Date: 22-Mar-2024
Our Ref: 2024/90291

**Application for Approval of Details Reserved by Condition
Town and Country Planning Act 1990
Planning (Listed Buildings and Conservation Areas) Act 1990**

**Discharge of conditions 4. (bin storage/collection) & 5. (noise assessment) on
previous permission no. 2023/92737 for Prior notification for change of use from
shop/restaurant to three dwellings
2, 4 & 6, Thornton Lodge Road, Thornton Lodge, Huddersfield, HD1 3JQ
Application Number: 2024/90291**

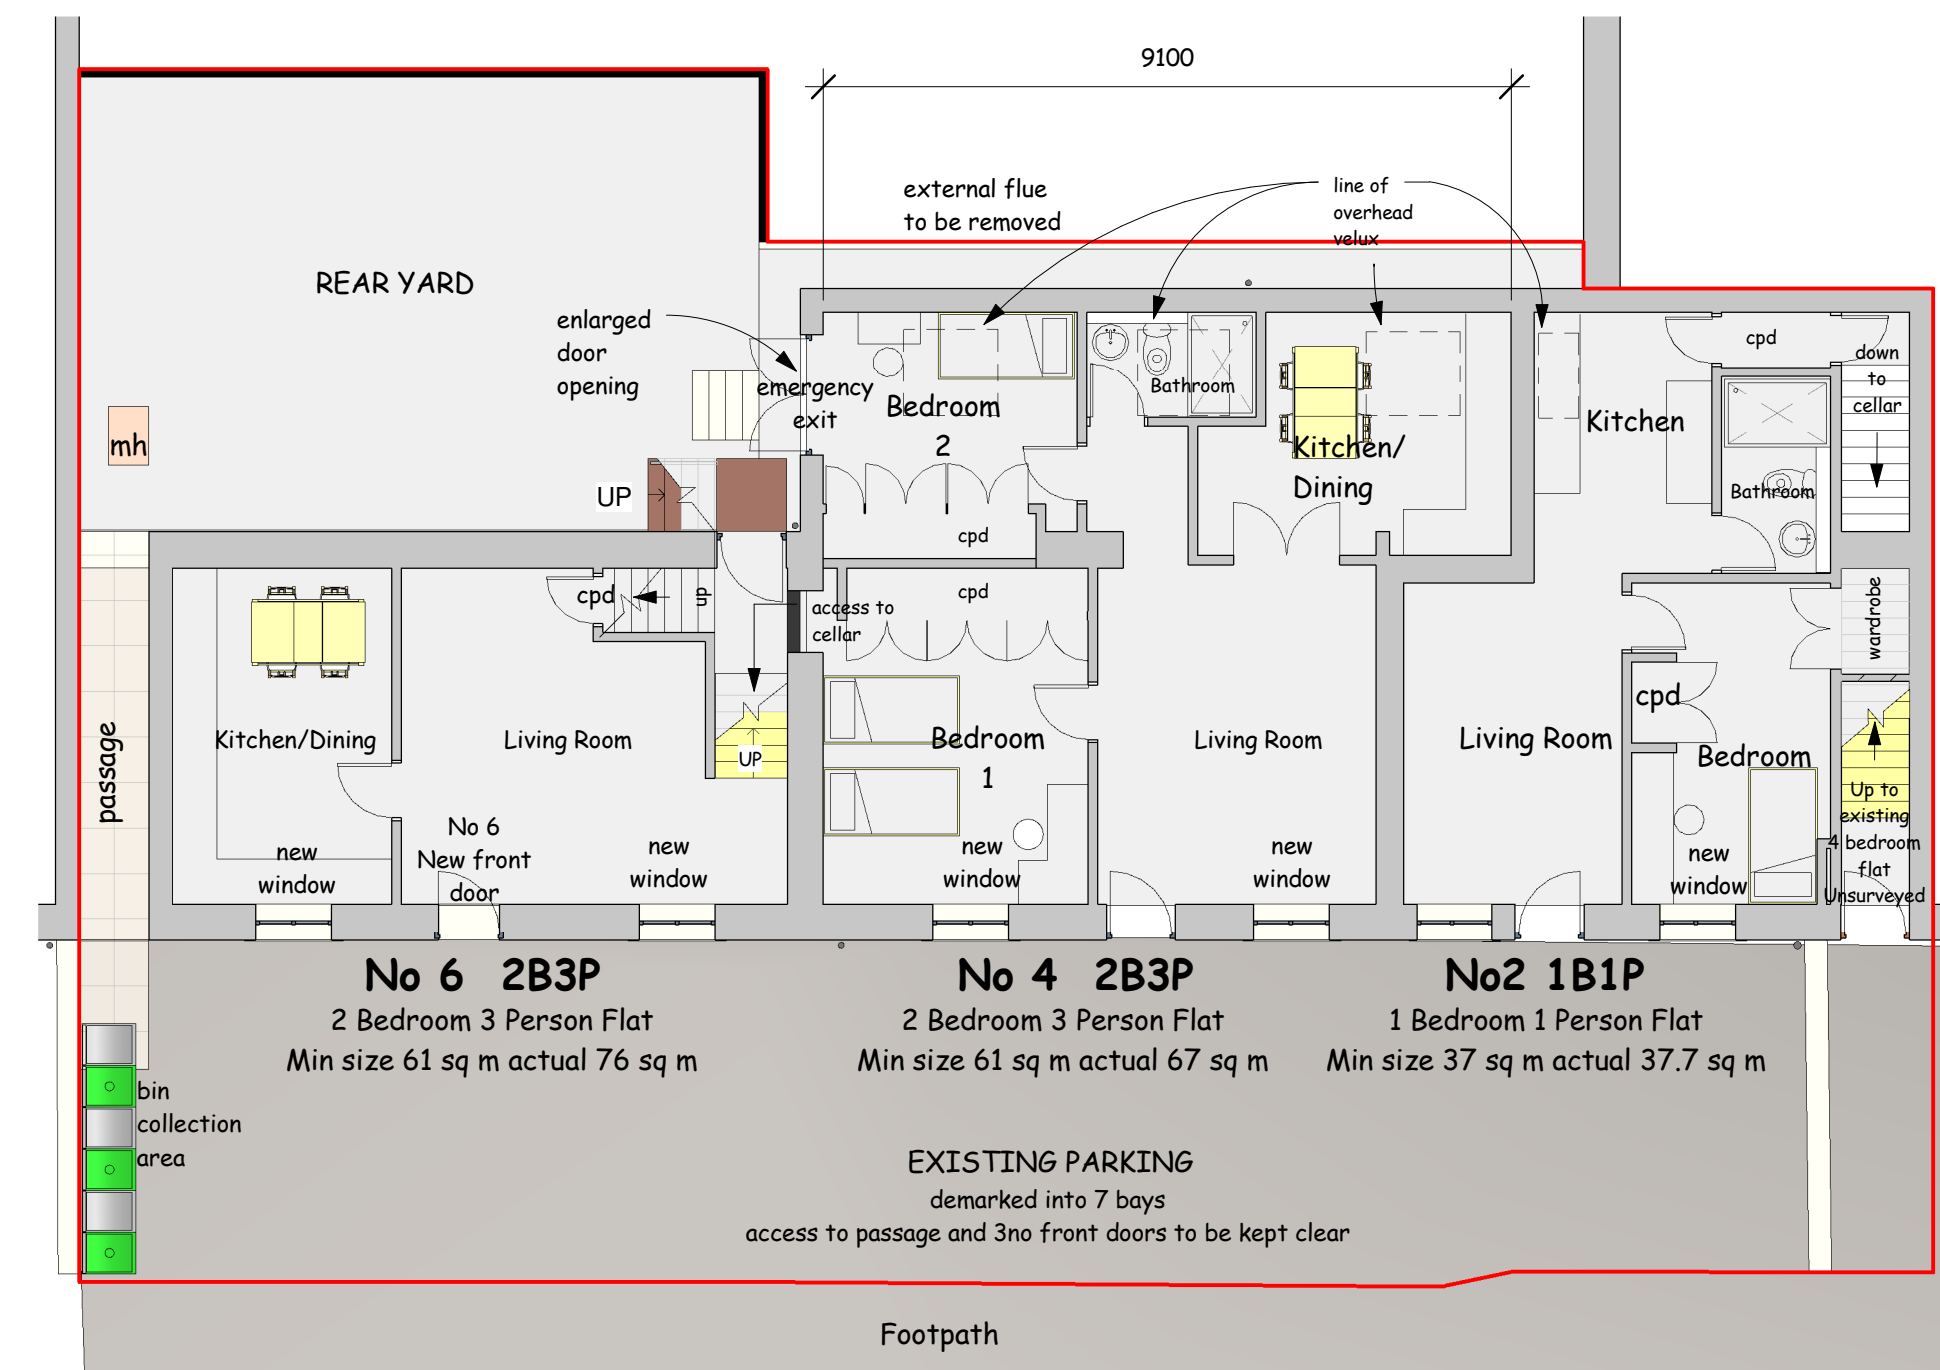
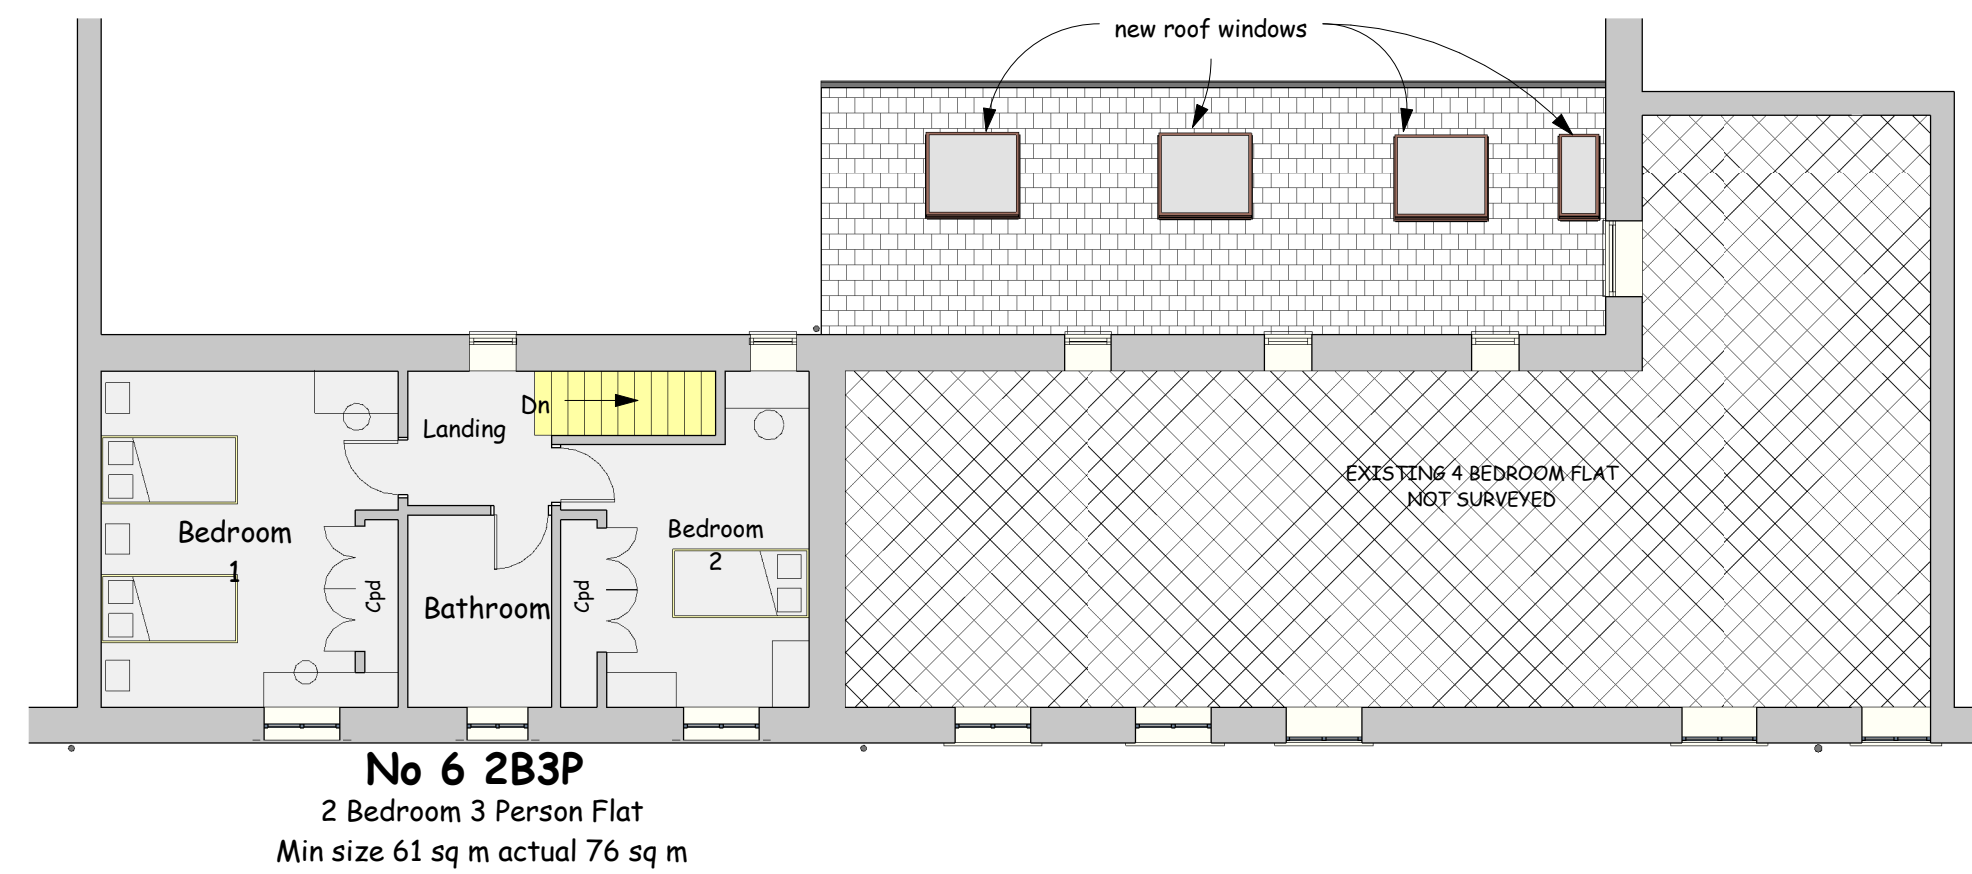
- A plan referenced 2304 – 02 – Rev: A

The plan demonstrates the collection of bin point to the front of the site, adjacent to the
parking area of No. 6.

Providing that the storage of bins is to the rear of the dwellings and the bins are only
presented at the collection point on collection day, in the area demonstrated on the
submitted plan and then returned to the rear of the site - and these arrangements retained
as such, free of obstruction, this condition shall be satisfied.
